WEST SUSSEX COUNTY COUNCIL CONSULTATION

TO:	Arun District Council FAO: Patrick Arthurs/David Easton
FROM:	WSCC - Highway Authority
DATE:	19 July 2022
LOCATION:	Barnham, Eastergate, Westergate BEW Parcel SC1 Barnham
SUBJECT:	BN/11/22/OUT Outline application with all matters reserved (except for the A29 Realignment) for the demolition of existing structures and mixed use development to provide residential dwellings (Use Class C3), Care Home/Senior Living Accommodation (Use Class E/F2/Sui Generis), a Primary School plus open space, landscaping, drainage and all other associated ancillary works; and realignment of the A29 and early connection to existing A29 including construction of a new road carriageway, junctions and associated infrastructure. This application also lies within the parish of Aldingbourne, affects the setting of listed buildings, affects the character & appearance of the Eastergate Church Lane Conservation Area and affects a Public Right of Way. This application is the subject of an Environmental Statement. An amendment received. More information received from Patrick Arthur's email.

DATE OF SITE VISIT:	31 March 2022
RECOMMENDATION:	More Information Required
S106 C

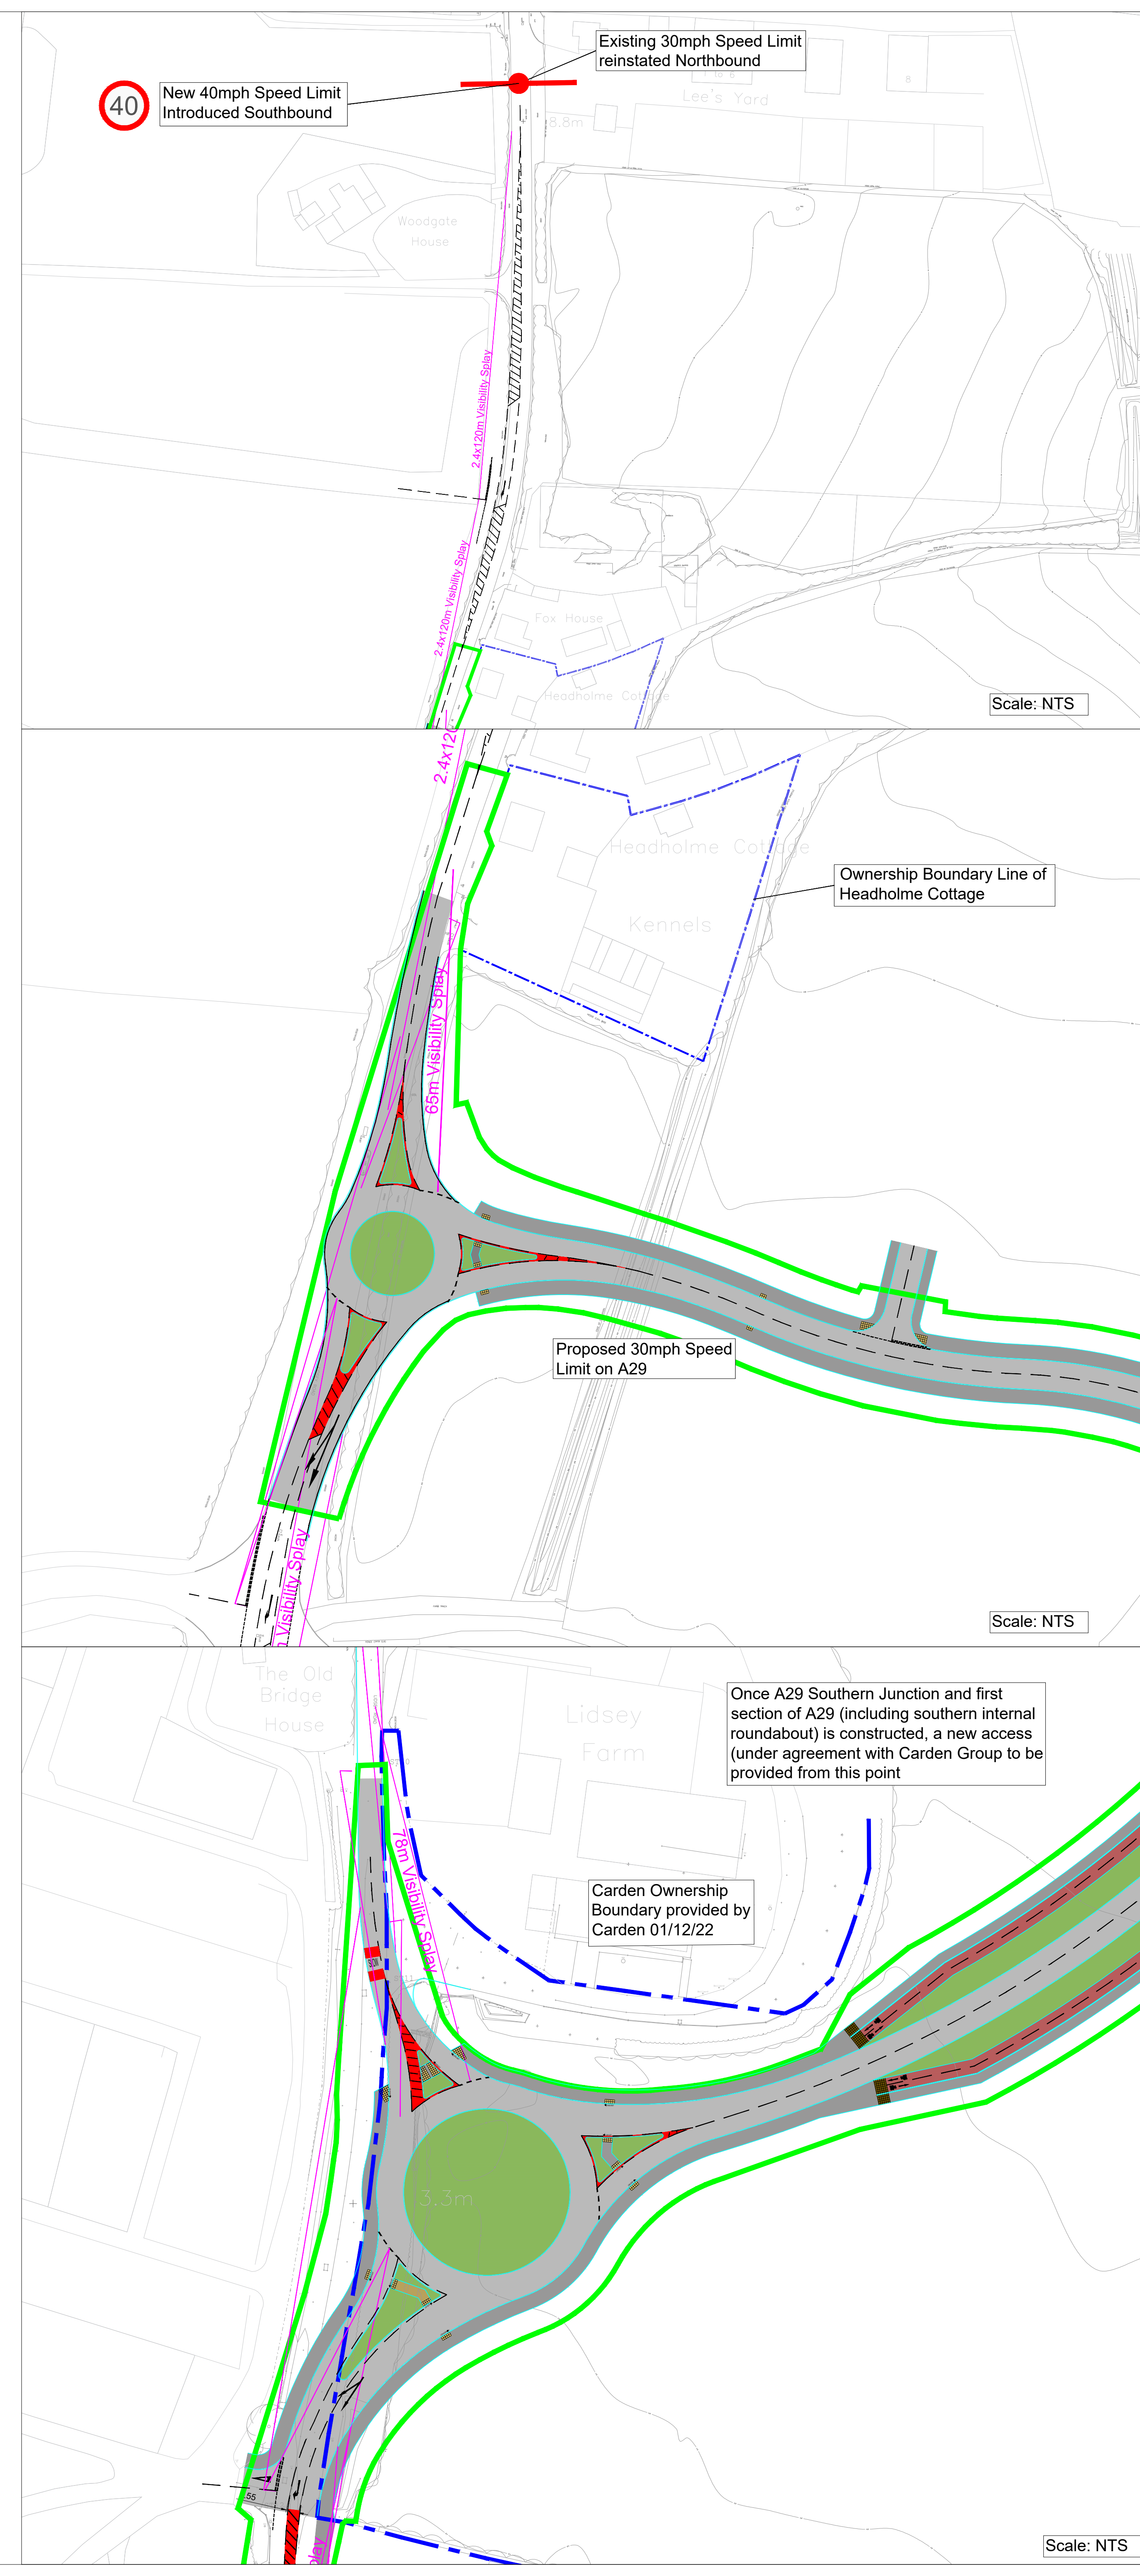
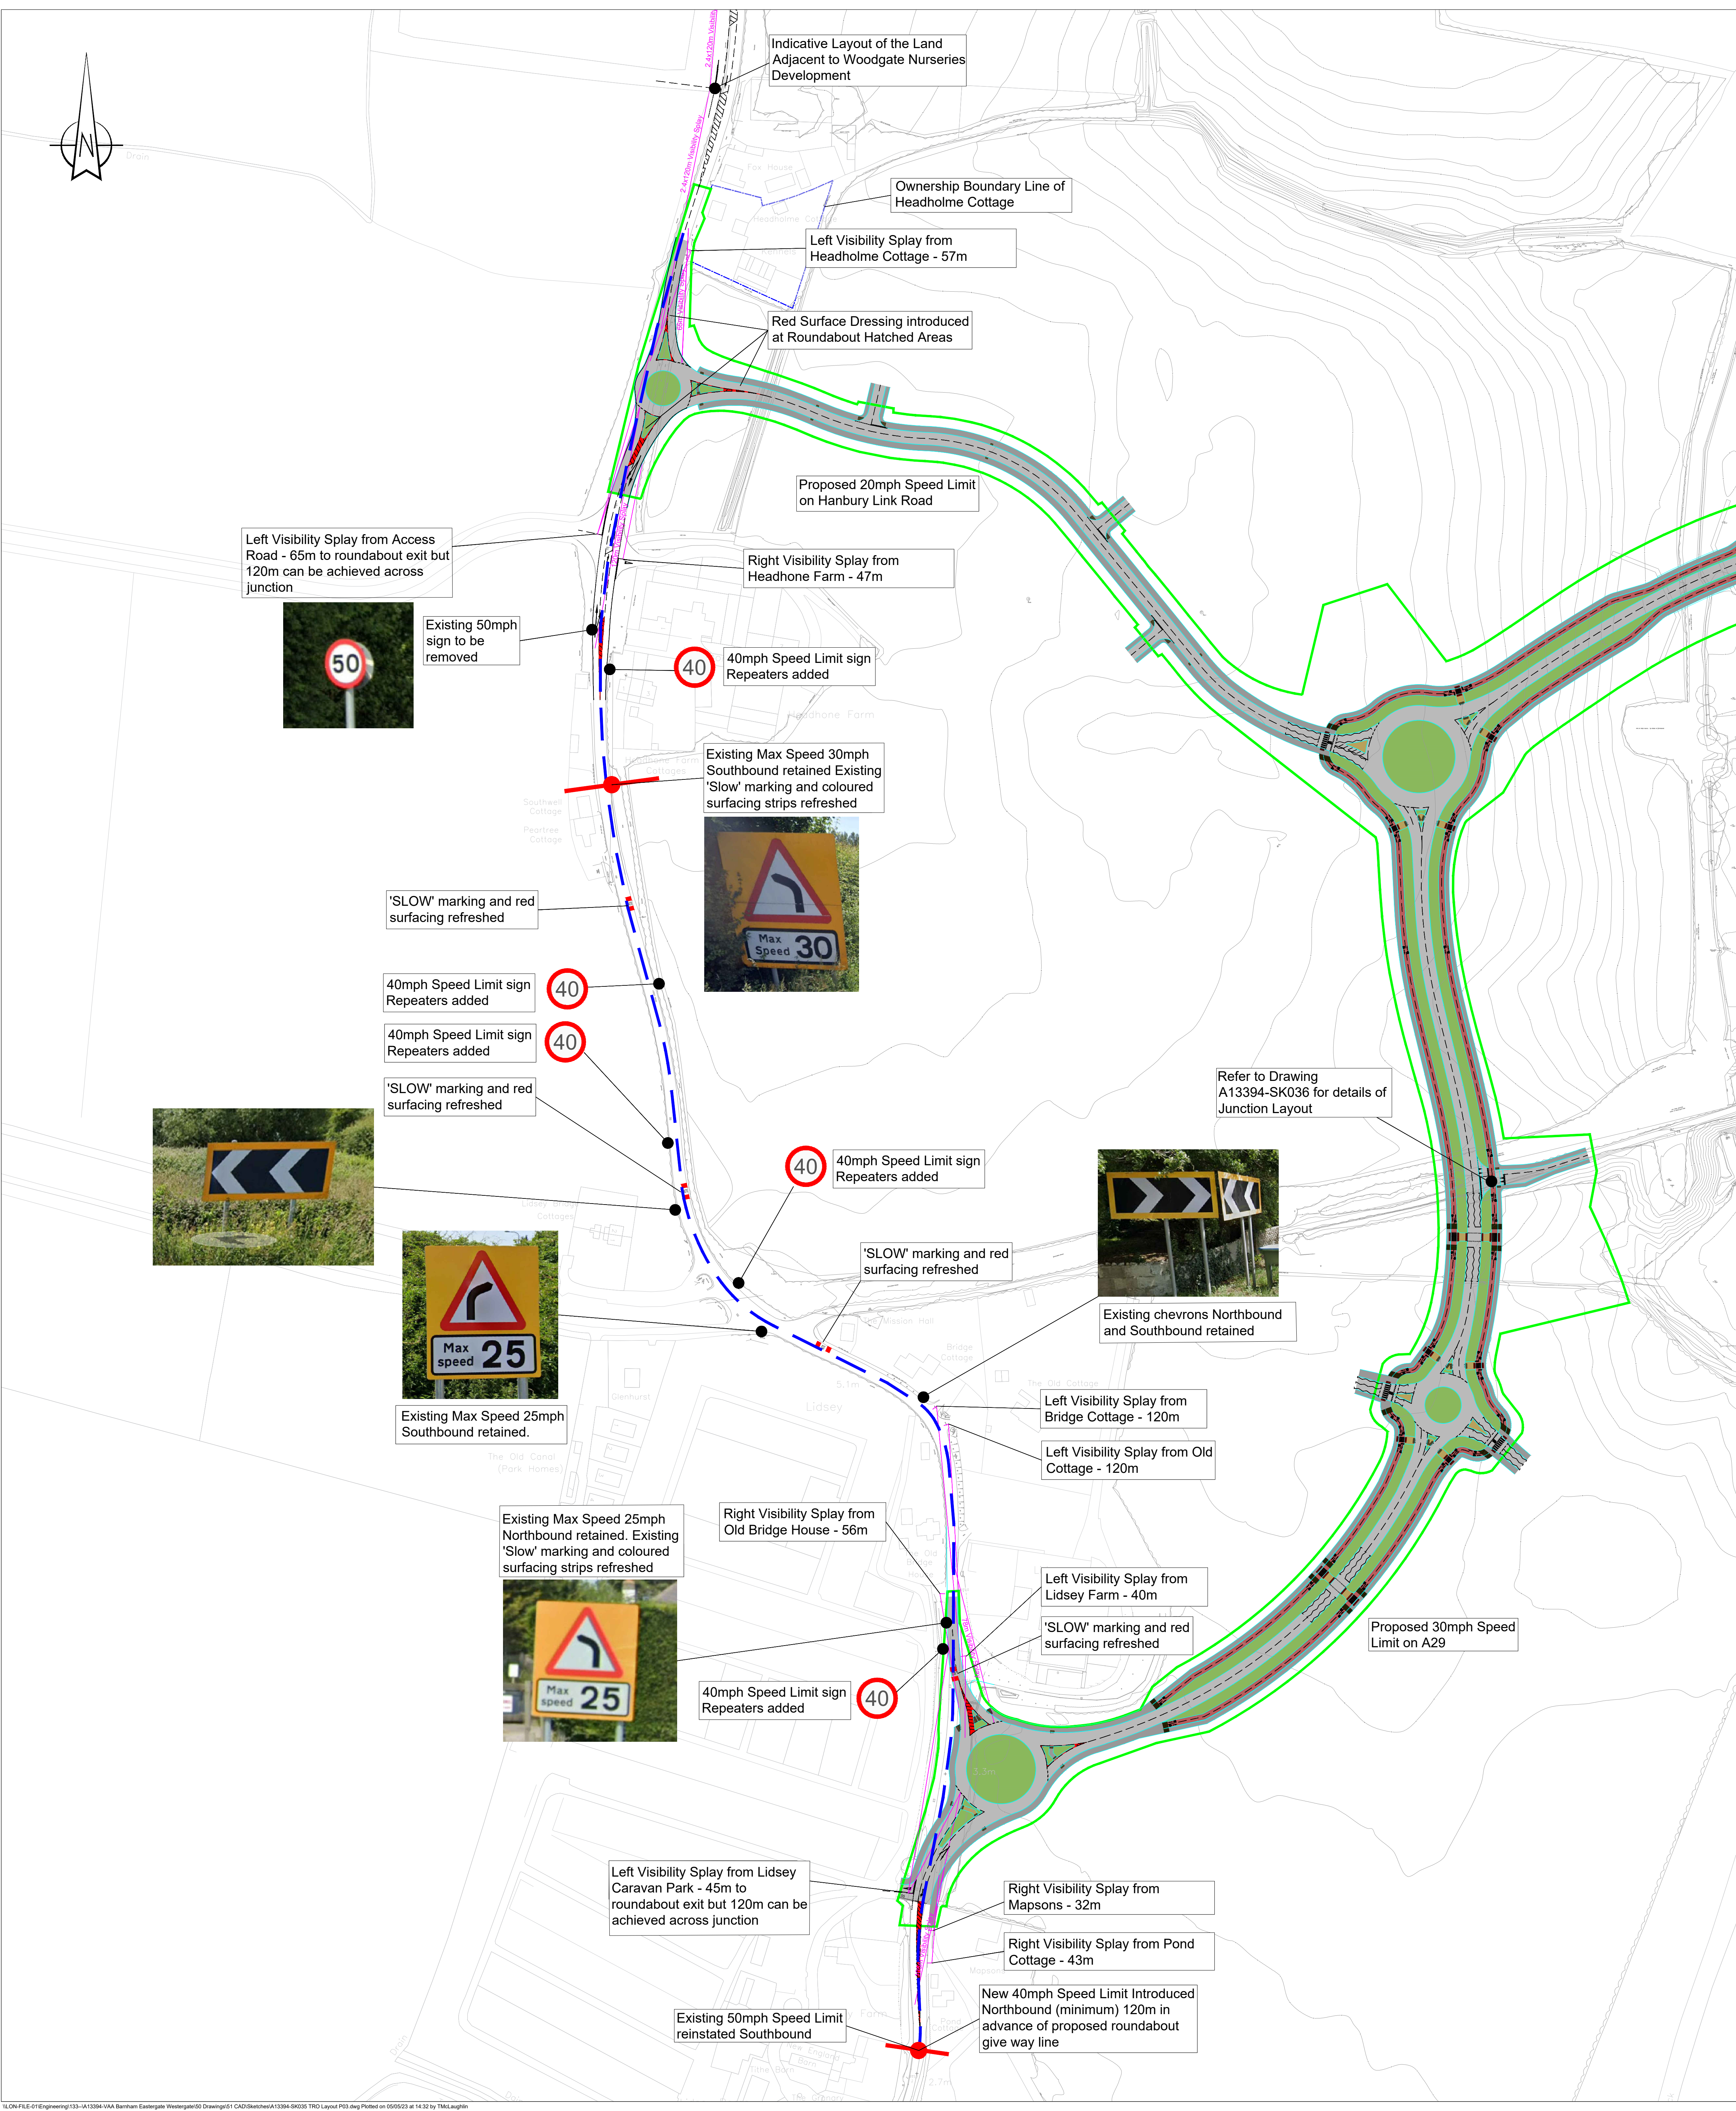
We anticipate less than 200 cycles per hour. <i>The 2.0m widths are absolute minimum widths and should only be used when there are constraints – which there don't appear to be here. Therefore, 3.0m paths should be provided both sides for the cycle component of the paths. 2.0m footways should be run alongside with the step in-between.</i> PF drawing A13394-PF-ZZ-XX-DR-CD-00001 P05 shows a physical delineation strip between footway and cycleway. A step can be incorporated but not specifically required and will complicate the drainage provisions along the footway/cycleway. If this is a WSCC design requirement it can be included as part of the Detailed Design without changing the principals of the design. <i>See comments above – a stepped demarcation should be provided and drainage designed accordingly.</i> On the main routes (at the roundabout intersections) we have shown a 3m wide combined footway/cycleway. For the minor connections cycle routes will be developed alongside the plot design if required. This information will be submitted as part of the relevant reserved matters applications for the plots.	Cycle Route Type	Direction	Peak hour cycle flow (either one way or two-way depending on cycle route type)	Desirable minimum width (m)	Absolute minimum at constraints (m)	Protected space for cycling (including light segregation, stepped cycle track, kerbed cycle track)	1 way	<200	2.0	1.5	200-800	2.2	2.0	>800	2.5	2.0		2 way	<300	3.0	2.0	>300-1000	3.0	2.5	>1000	4.0	3.0
Cycle Route Type	Direction	Peak hour cycle flow (either one way or two-way depending on cycle route type)	Desirable minimum width (m)	Absolute minimum at constraints (m)																								
Protected space for cycling (including light segregation, stepped cycle track, kerbed cycle track)	1 way	<200	2.0	1.5																								
		200-800	2.2	2.0																								
		>800	2.5	2.0																								
	2 way	<300	3.0	2.0																								
		>300-1000	3.0	2.5																								
		>1000	4.0	3.0																								
A 'step' shown to differentiate foot and cycle components of the paths referred to in point 1 above should be shown.																												
No continuation of cycle routes is shown into the side roads.

<i>As stated in previous comments, the side roads running off the new A29 are included in the red edging and as such, WSCC need to see the continuation of the paths at this current planning stage.</i>
--	--

Central islands preventing right hand turns. These appear to be very narrow and may lead to signs being hit by vehicles on either-end and may, in practice, lead to higher traffic speeds past them. And, no rationale is provided as to why they are proposed. Applicant to look to provide right hand turning lanes instead for the locations where the central 'barriers' are shown.	The central island physical widths are 1.5m and therefore a sign can be centrally located (for example a left turn only sign) with a 0.45mm offset from the kerb edge. Additionally, the proposed 1040 hatch markings which add another 1m either side provide additional protection. During initial discussions with Arun District Council and West Sussex County Council the team were advised to minimise full access junctions to maintain throughput of traffic. Therefore, under the direction of WSCC we provided central roundabouts linking through traffic and limiting side road traffic to left-in/left-out. <i>The creation of all-movement junctions will help with permeability and may have a slowing effect on traffic speeds which could (alongside other mitigation) assist with pursuing a 30mph speed limit along the length of the new A29 road. The other option might be to re-design as roundabouts, thereby introducing further 'breaks' in traffic flow and speeds.</i>

The access to the industrial/commercial facility north of roundabout (Lidsey Farm) is not clearly shown, nor does it appear to have been considered in the Road Safety Audit, nor tracked for the size and type of vehicles that use it. As the kerb line is being altered and given its proximity to the new roundabout on Lidsey Road, this information must be provided, please.	The existing access to Lidsey Farm is to be maintained and is reflected on the submitted highways plans. A visibility splay of 41m can currently be achieved in land which is either public highway or land owned/ the existing access /controlled by The Southern Consortium. Please see attached drawing A13394-SK034. <i>As-per CHA previous comments, this needs looking at in more detail, including having it tracked for a selection of vehicles (including HGVs) and safety audited in its revised guise. *Please also see comments elsewhere in this response to do with proposed speed limit changes at this location.</i>

No detail is shown of the transition of the roundabout on existing A29 and the existing right hand turning lane, also on existing A29 (the latter serving the waste site). This point has also been picked up in the submitted Road Safety Audit.	Please find attached a revised version of drawing A13394-PF-ZZ-XX-DR-CD-00107 incorporating the existing Ghost Island junction on south of the proposed Hanbury Link Roundabout serving the waste site. <i>Until the design speed is discussed and settled, it would be difficult to take a view on how to consider geometric parameters – whether to consider them as based on a design speed of 30mph or the existing 50mph.</i> <i>The designers will need to carry out a design audit to demonstrate that the resultant ghost island to the landfill site remains within the requirements of CD 123. From a cursory look, it looks unlikely that the ghost island geometric parameters will meet the requirements and so the designers will need to decide how to progress it if it doesn't.</i> <i>The stagger distance between the proposed roundabout and the landfill junction will also need to be looked at in terms of compliance with standards.</i> <i>Applicant to set-out what design speed this has been designed to.</i>
